From: Phil Rowe [REDACTED]
Sent: 10 September 2020 17:25
To: Planning <Planning@arun.gov.uk>; Zac Denton <Zac.Denton@arun.gov.uk>
Subject: Planning Application R/156/20/PL 31 Albert Road Rustington BN16 3JT - letter of objection

I have been instructed to object to the above application. For the record I used to work as Worthing Council enforcement manager in the past so I am very familiar with the area and planning considerations.

DRAWING TITLE
PROPOSED FLOOR PLANS & ROOF PLAN

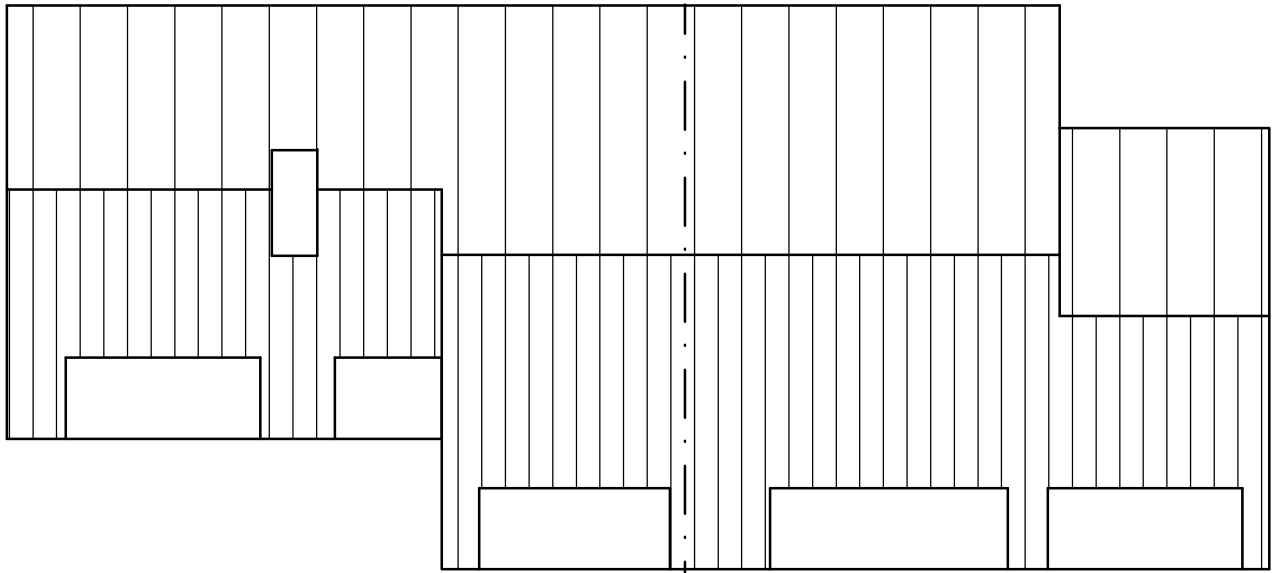
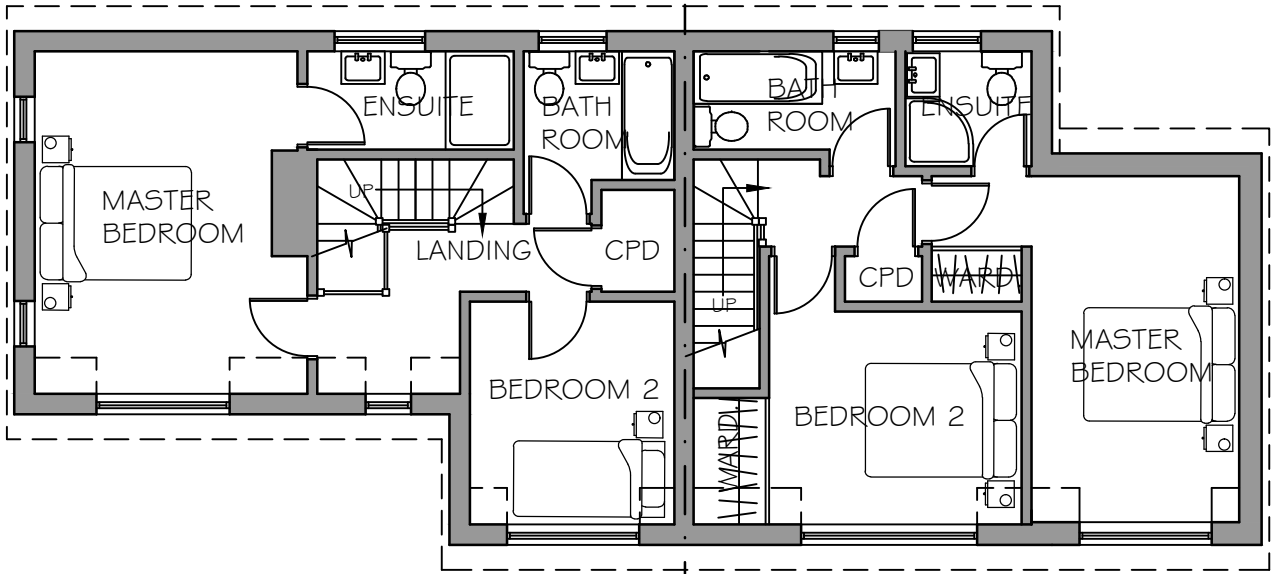
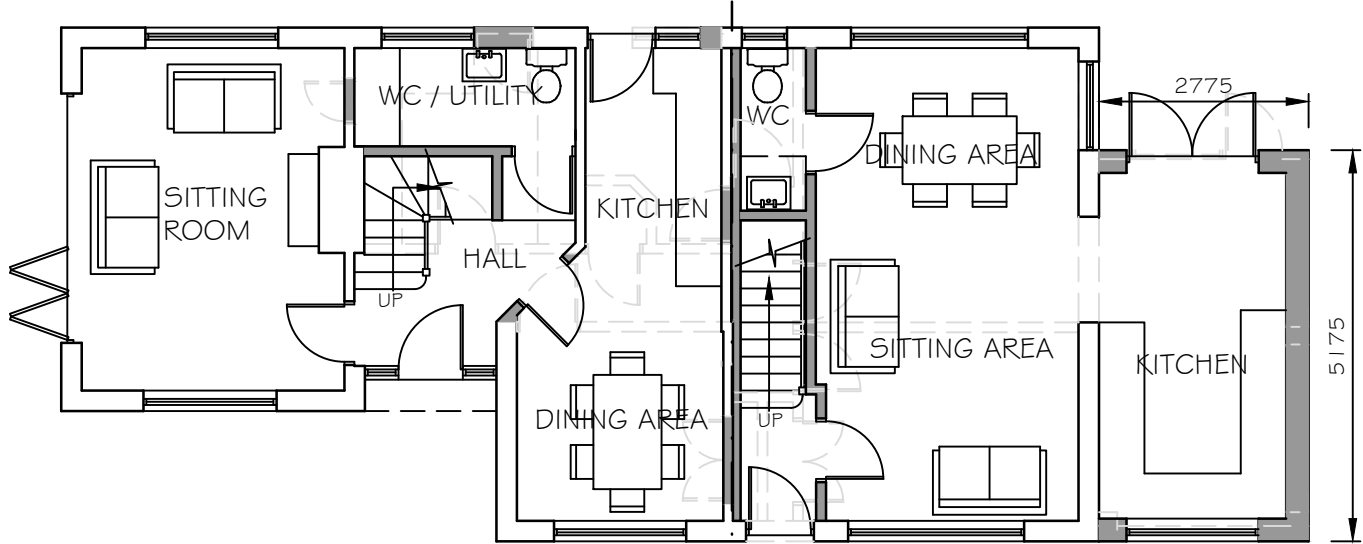
- Insufficient garden amenity area through additional dwelling creating overdevelopment concerns. The proposed plot sizes would be unacceptably

DRAWING TITLE
PROPOSED ELEVATIONS

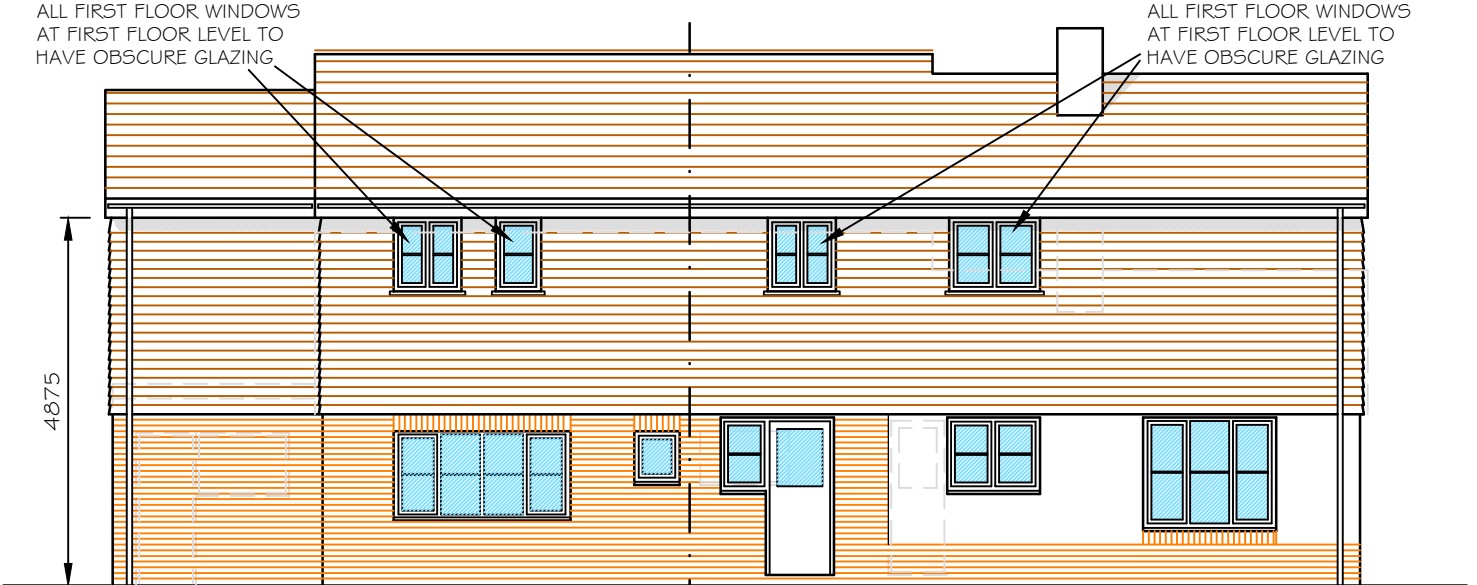
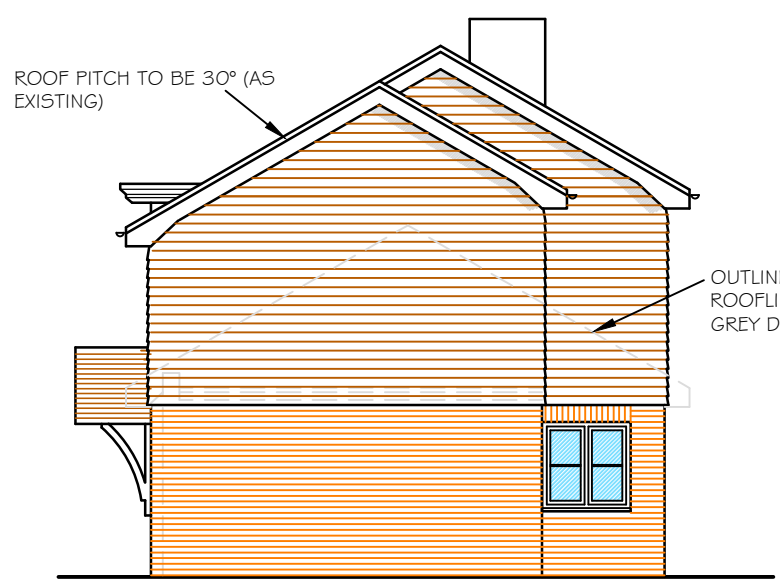
- The endeavours to create 2 dwellings in lieu of the simple, contextually appropriate bungalow has similarly led to a cumbersome design in an attempt to address the over development point and shoe horn in 2 dwellings. Putting profit before design is not a good planning principle.
- Bulk and overbearing on the street scene to the detriment of the residential amenities of the neighbouring bungalow no 29 Albert Road , 22&24 Albert Road and 23 and 25 Mill Lane.
- Overlooking is clearly a concern of the architect hence the use of obscurely glazed first floor rear windows. I accept that these are to bathrooms but it does nothing in terms of visual amenity. It is also notoriously difficult to monitor non opening window conditions.
